RR359 Emma Glass

APFP Reference
Regulation 5(2)(k)

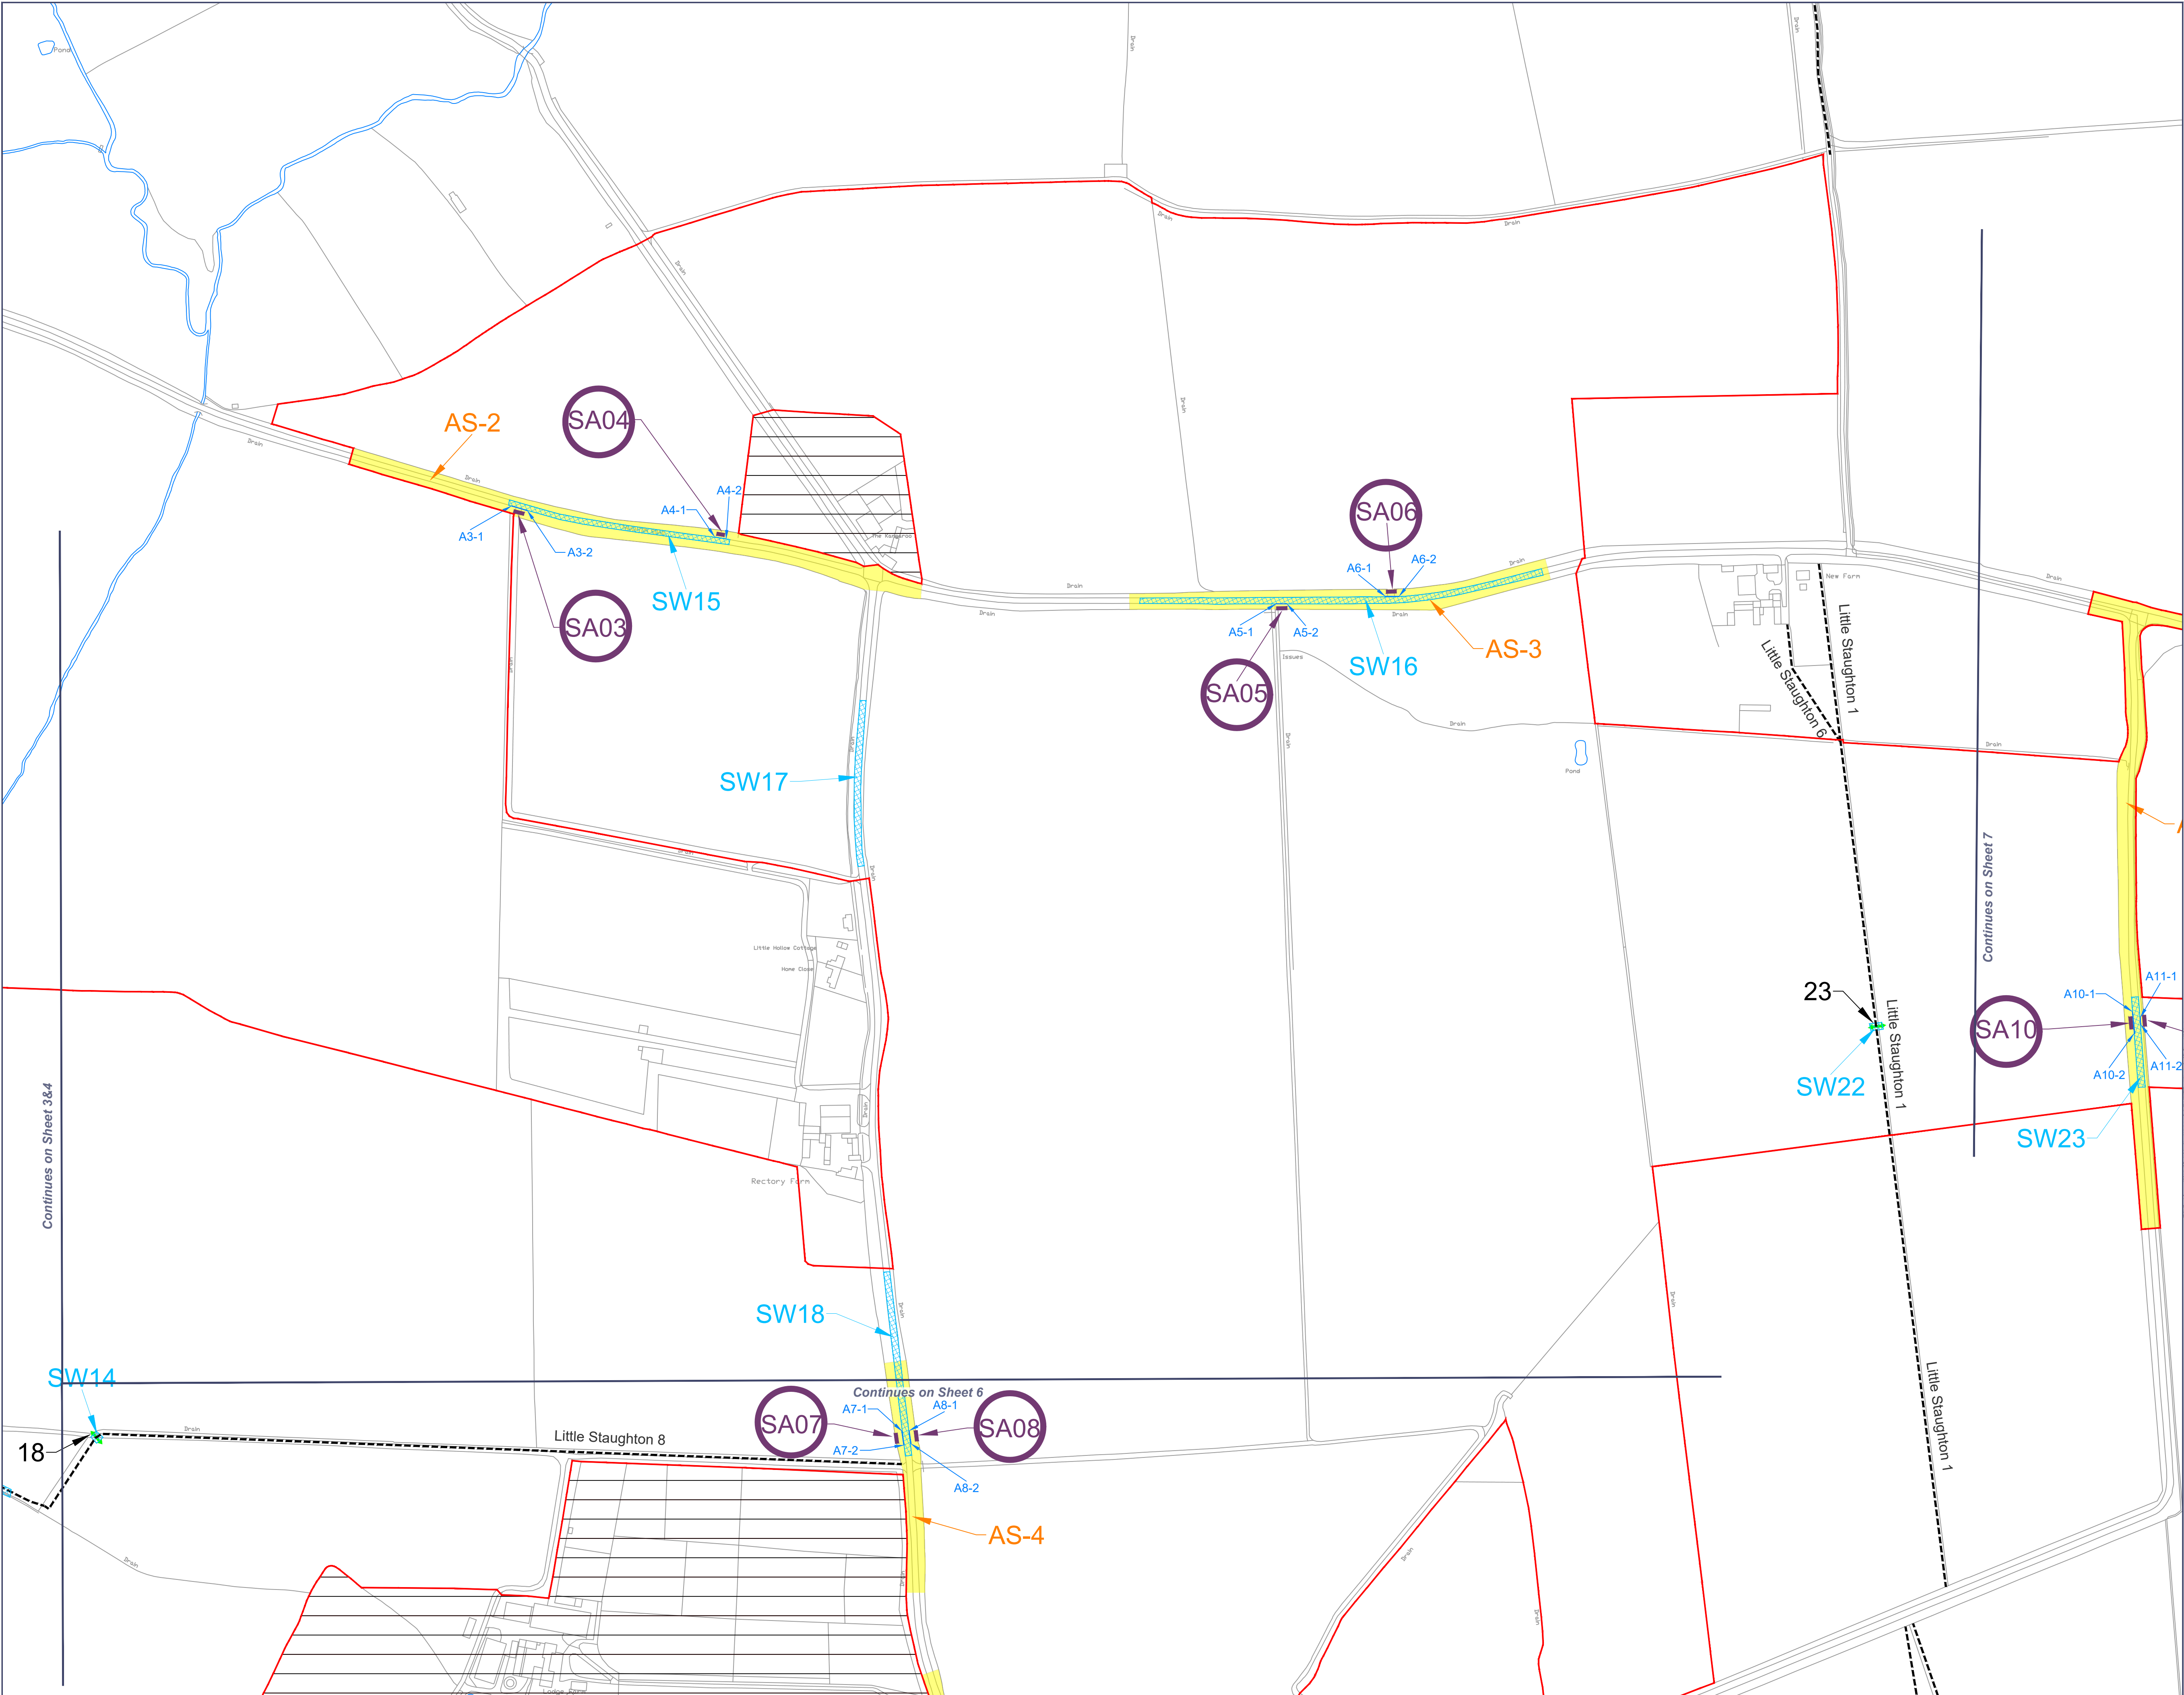
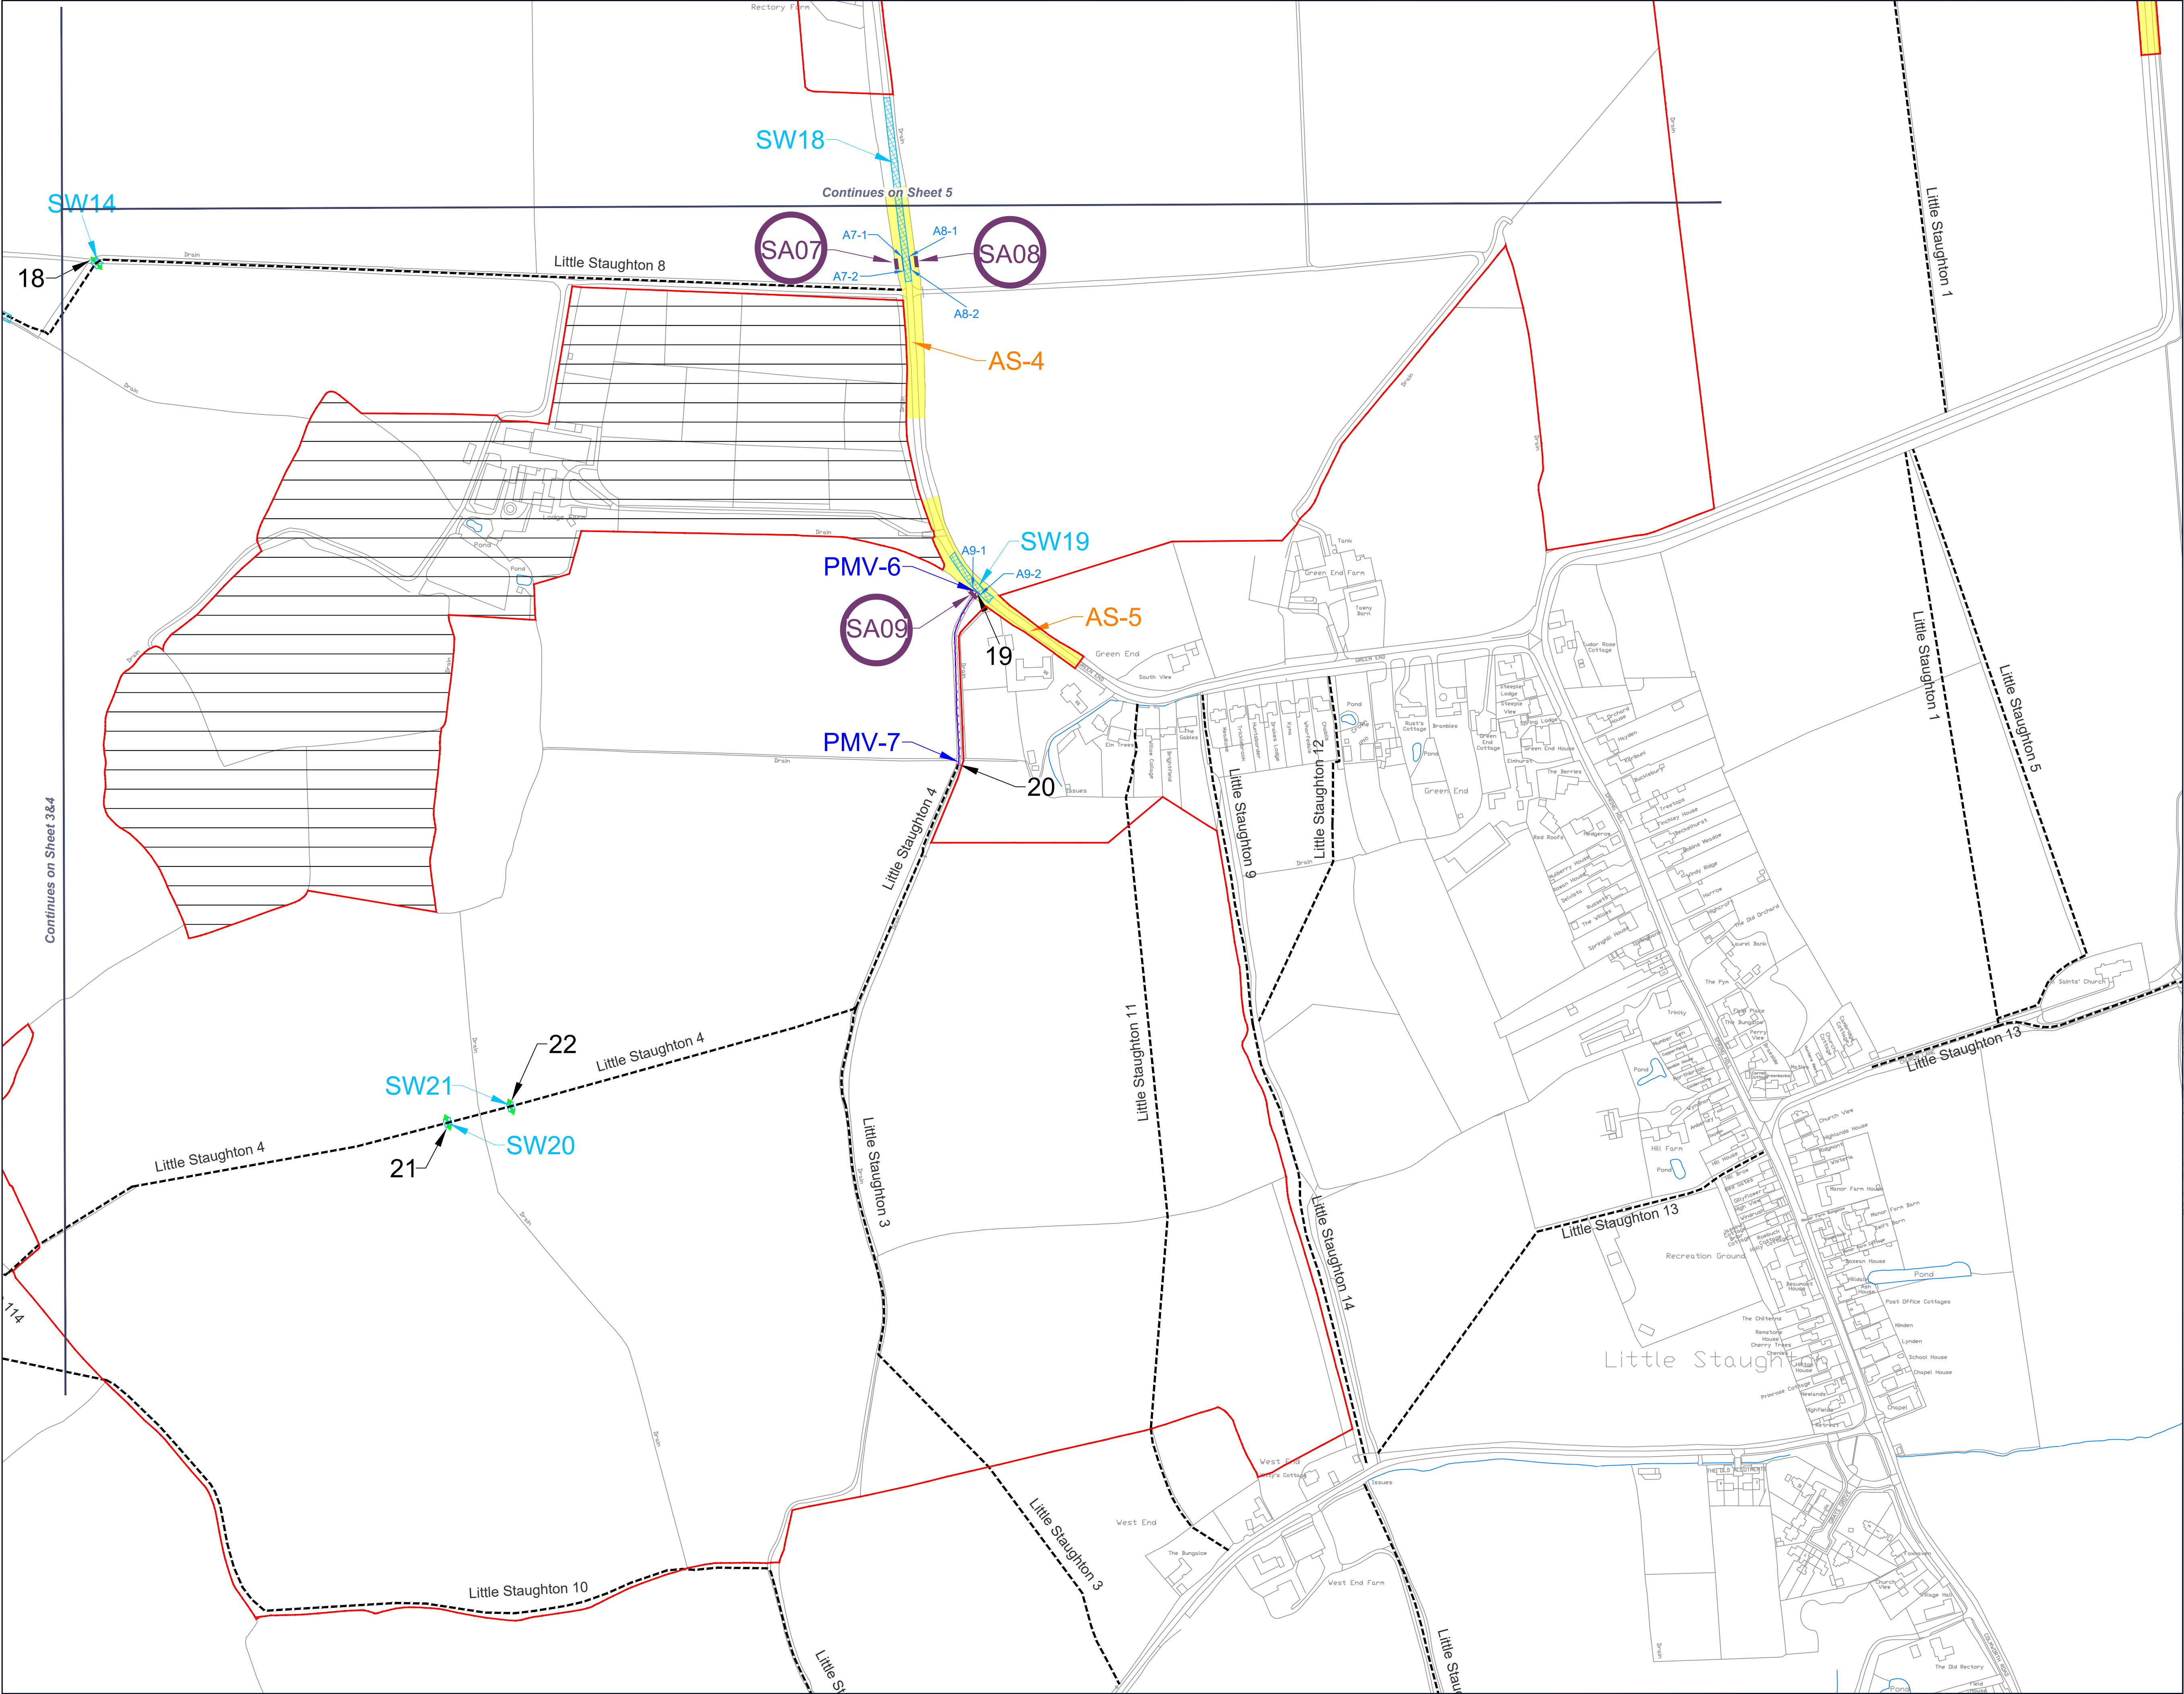
Finally, there is the issue of public rights of way. The suggestion that footpaths and bridleways will remain safely accessible during a 30-month construction period is unrealistic.

How will the safety of walkers, cyclists, and horse riders be guaranteed in practice?
